June 9, 2023

Site: 4719 86th Ave SE
Mercer Island, WA 98040
TPN: 7598100421
Area: 11,500 sq ft. = .26 acres

Re: RFI from John Kenney:

TREE RETENTION NOTE

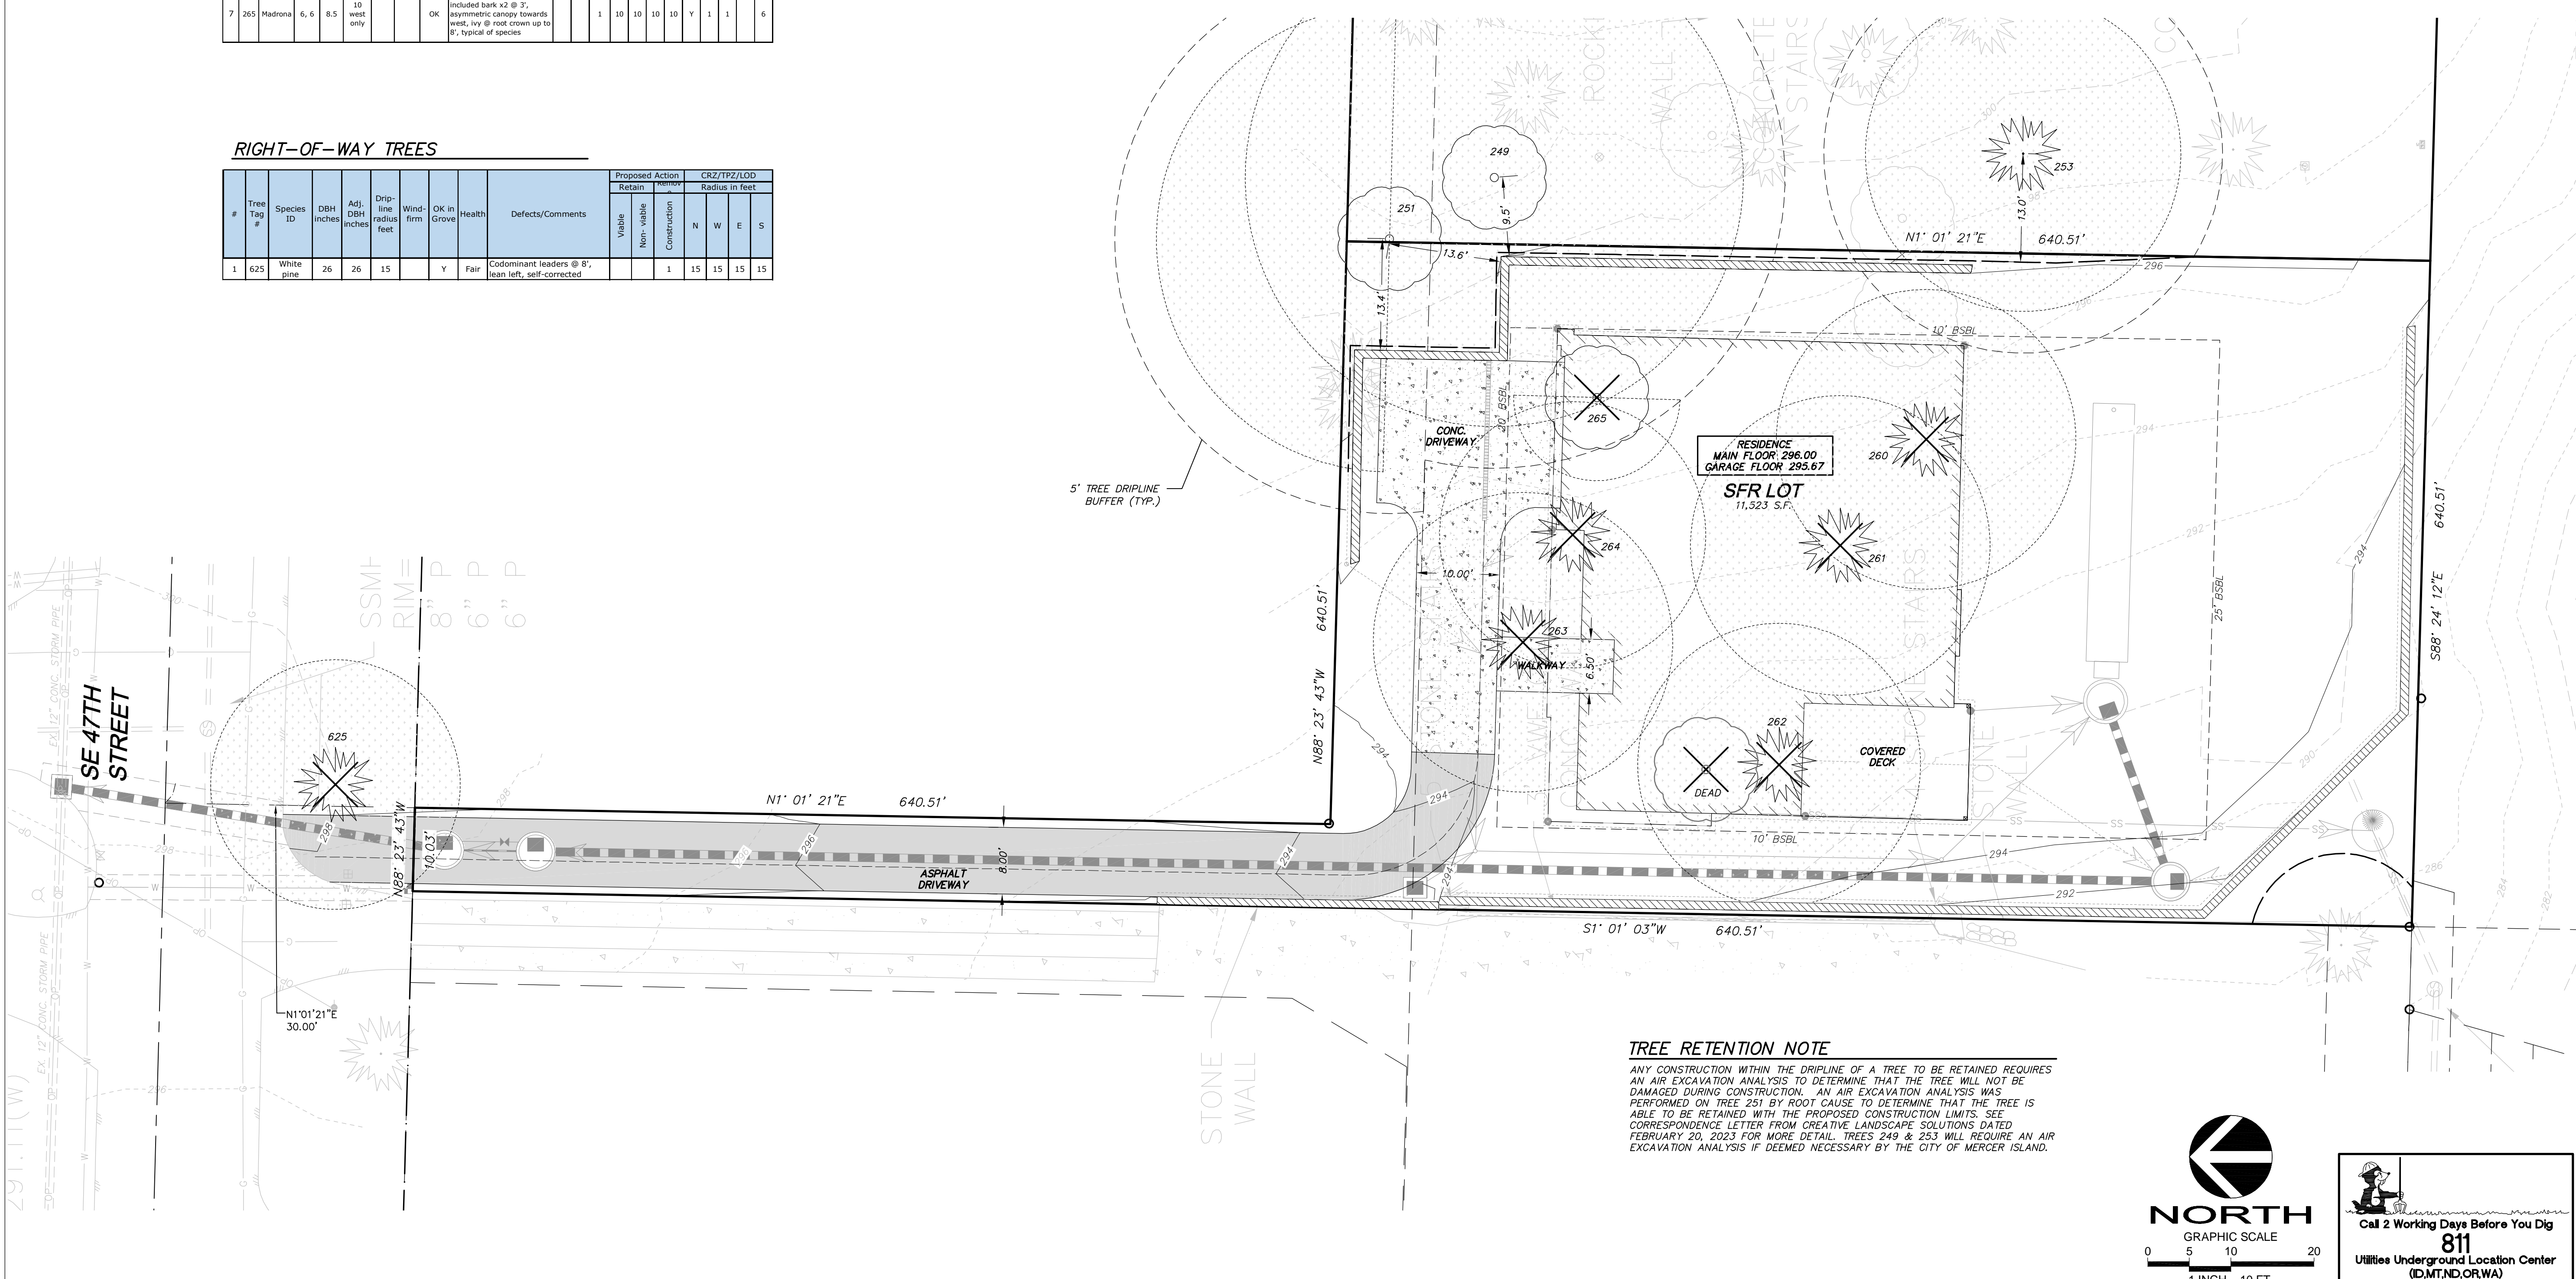
(Repeat comment provided at intake screening) Have the project arborist or landscape architect provide or approve tree replacement plan. Trees must be planted to survive long term. The only native tree, a cedar, is planted 10 feet from the home. This will soon become a nuisance because of the size of tree at maturity. Half the trees must be native species according to MICC19.10.070. Three trees are planted within five feet of the house, there is room in the back yard for planting outside the SS easement. Move these trees to have room to mature long term. I have emailed the fee in lieu form you requested for you to complete. The replacement tree for the right of way tree must be on your private property since no room on the right of way at this location exists. No tree watering plan is provided to ensure the trees survive. Irrigation and associated water service should be planned for now.

Show the different options for building pad/utility placement/retaining walls that retain the largest number or best suitable for retention exceptional trees. (Is an east/west or north/south configuration best for tree retainage?)

Determine the allowed setbacks and maximum gross floor area and configure the building pad to best avoid any exceptional trees and retain 30 percent of large trees (what building can fit without encroaching into exceptional trees dripline). You may need to modify the traditional rectangle building pad to accommodate for exceptional trees dripline.

*6. I located a tree in the ROW that has previously not been discussed and I am adding that now. I am presuming its removal will require an additional 3 trees for mitigation. The tree has been tagged #625 and is located on the north side of the property adjacent to a 10' wide roadway access. The tree is viable and needs to be removed. I have updated the spreadsheet to include it in the discussion and modified my summary to consider the removal and mitigation.

I have updated the included report to show that you are unable to replant the onsite mitigation for removed trees as required by code because there was no space for the plantings that was 10' from hardscape or utilities or building footings. Instead, you will pay a fee-in-lieu of for all eighteen (18) ROW and Onsite replacement trees.

There are two (2) exceptional trees (#262 and #262) located in the proposed building site. Their dripline + 5' buffer are shown on the Tree Retention Sheet. Permission to remove the two (2) trees is requested because the driveway is the maximum distance the fire Department will allow from the street. To move the house to a different location requires an increase in the driveway access which in turn makes the structure a fire hazard.

Applicant proposes to mitigate for the loss of the tree by replanting the same species 10' further to the east in the easement.
